**KIRKLEES METROPOLITAN COUNCIL
INVESTMENT & REGENERATION SERVICE**

**DELEGATED DECISION TO DETERMINE APPLICATIONS FOR
NON-MATERIAL AMENDMENTS**

Reference No:	2025/NM/93365/E
Site Address:	Cross Rink Street, Batley, WF17 6BH
Description:	Non material amendment to previous permission 2009/93382 for erection of retail development
Recommending Officer:	Katie Chew

SECTION 1-1

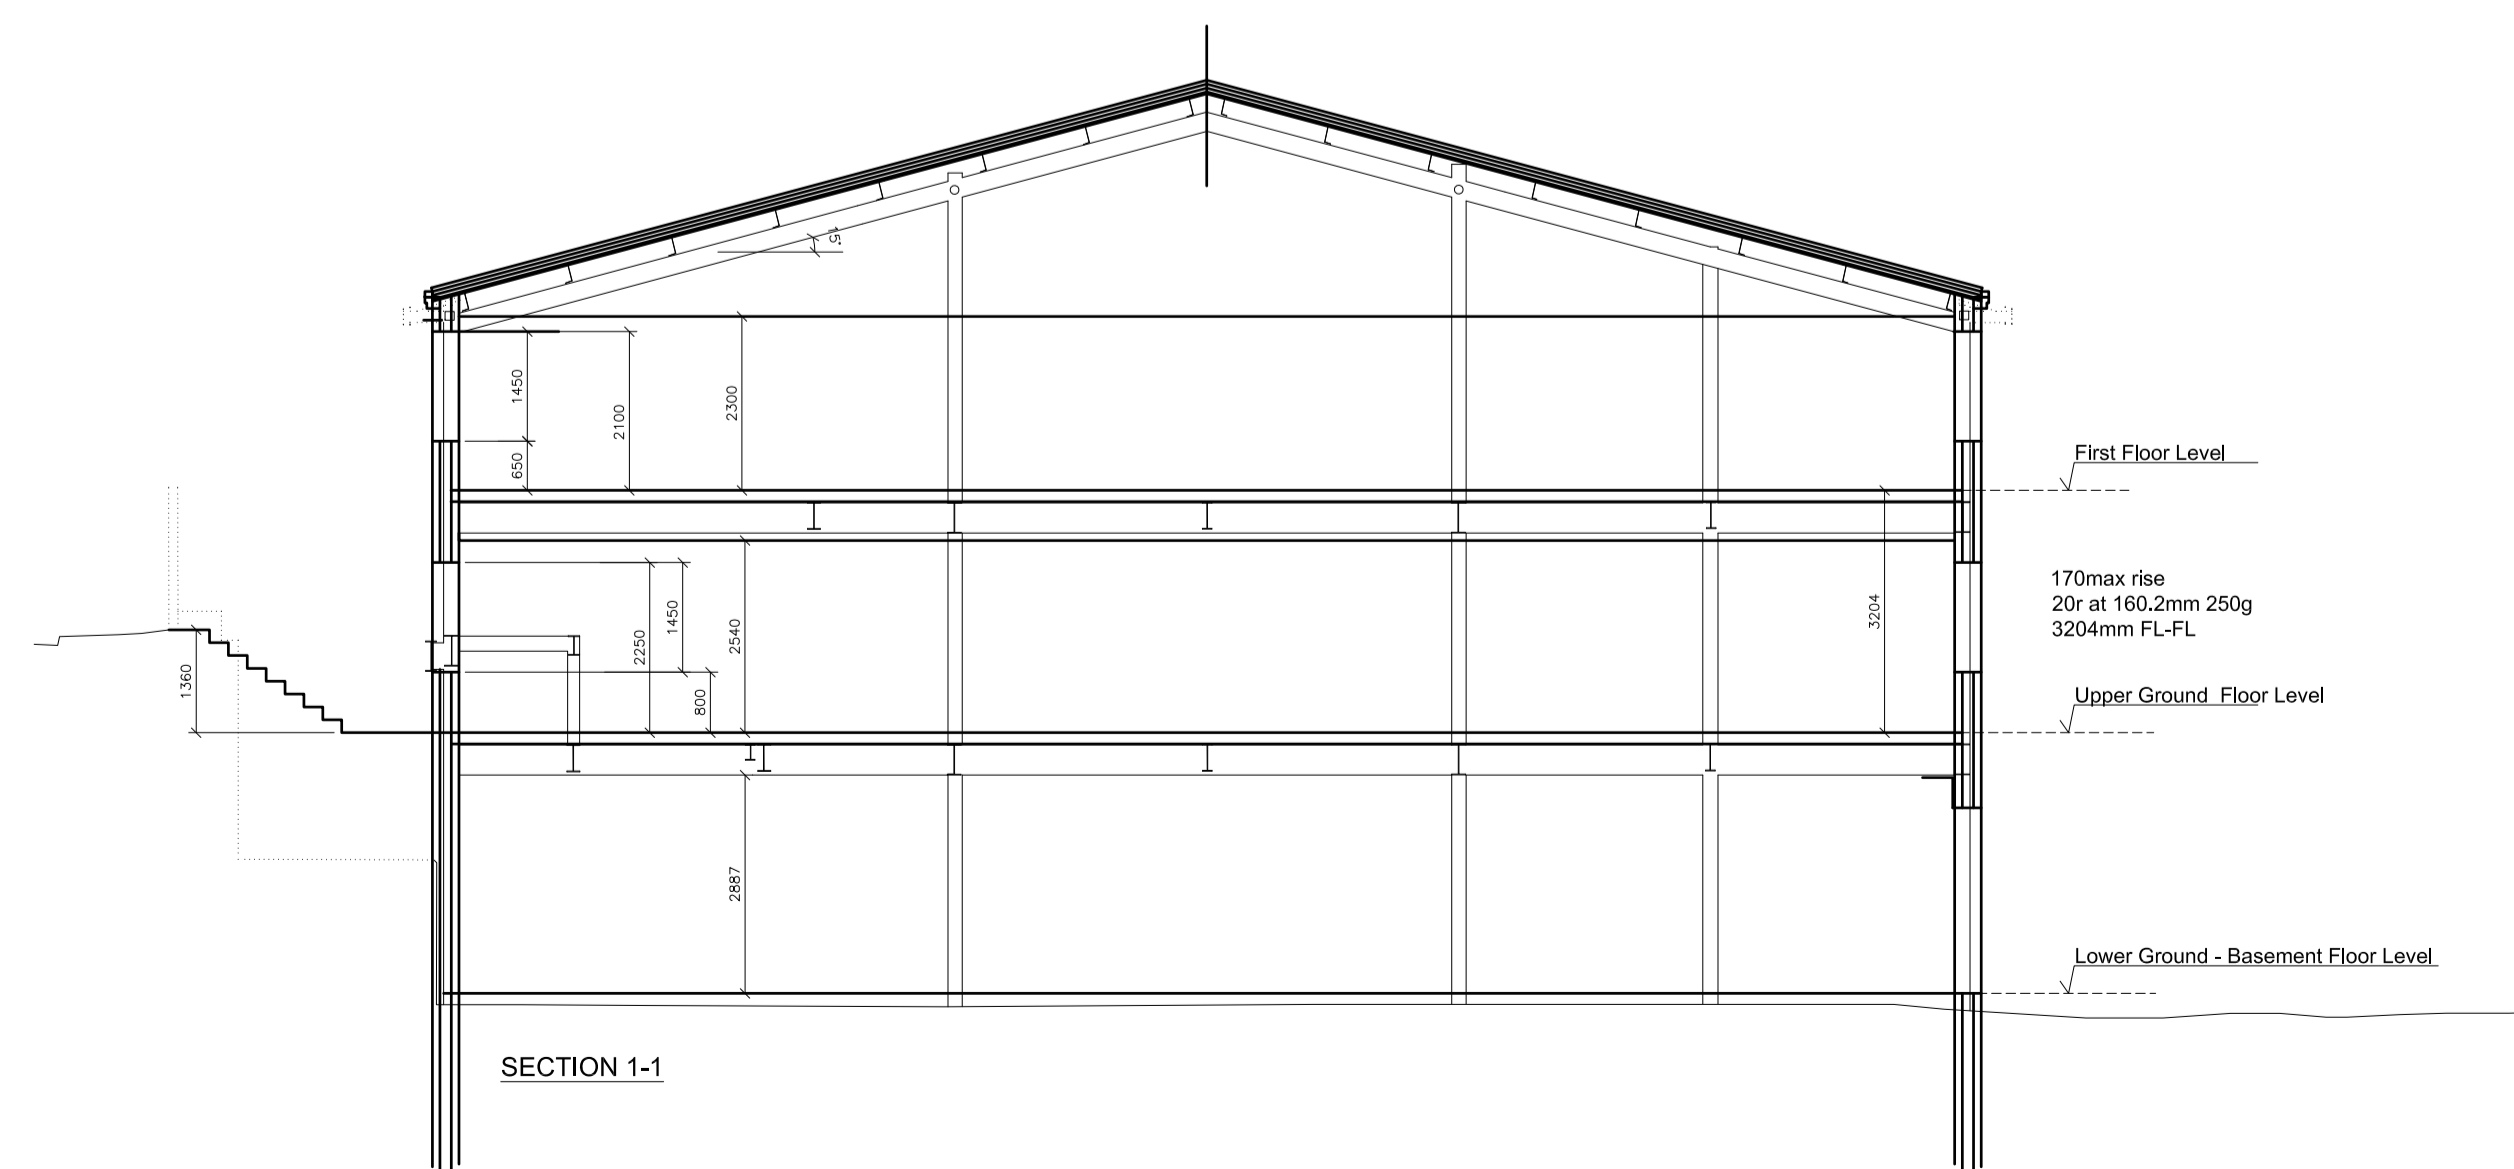
Amendments have been sought to the originally approved structure to increase its height by around 0.7m. Changes have also been made throughout the external elevations in terms of the design, window and door arrangements. No details have been provided in respect of materials and therefore Officers cannot confirm whether these are to be as approved, or not. The access and parking arrangements appear to have also changed, with a smaller, gated entrance shown on the submitted block plan, than previously approved. Parking numbers have changed with an increase of 2 spaces, due to the loss of 2 originally approved disabled spaces. Finally, the overall use of the site is proposed to be changed from a retail unit with storage and staff facilities, to 10 flats and warehouse storage.

Given the increase in height, altered arrangement of windows and doors, lack of detail in terms of materials used, and a change to the parking layout and use overall of the site, Officers cannot give a view on these matters at this time. A full assessment would need to be undertaken under a full planning application to ascertain whether the proposals would result in a detrimental impact either visually or in terms of living conditions.

YES. The proposals seek to increase the size of the building by 0.7m.

- Amendments to the originally approved structure to increase its height by around 0.7m.
- Changes made throughout the external elevations in terms of the design, window and door arrangements.
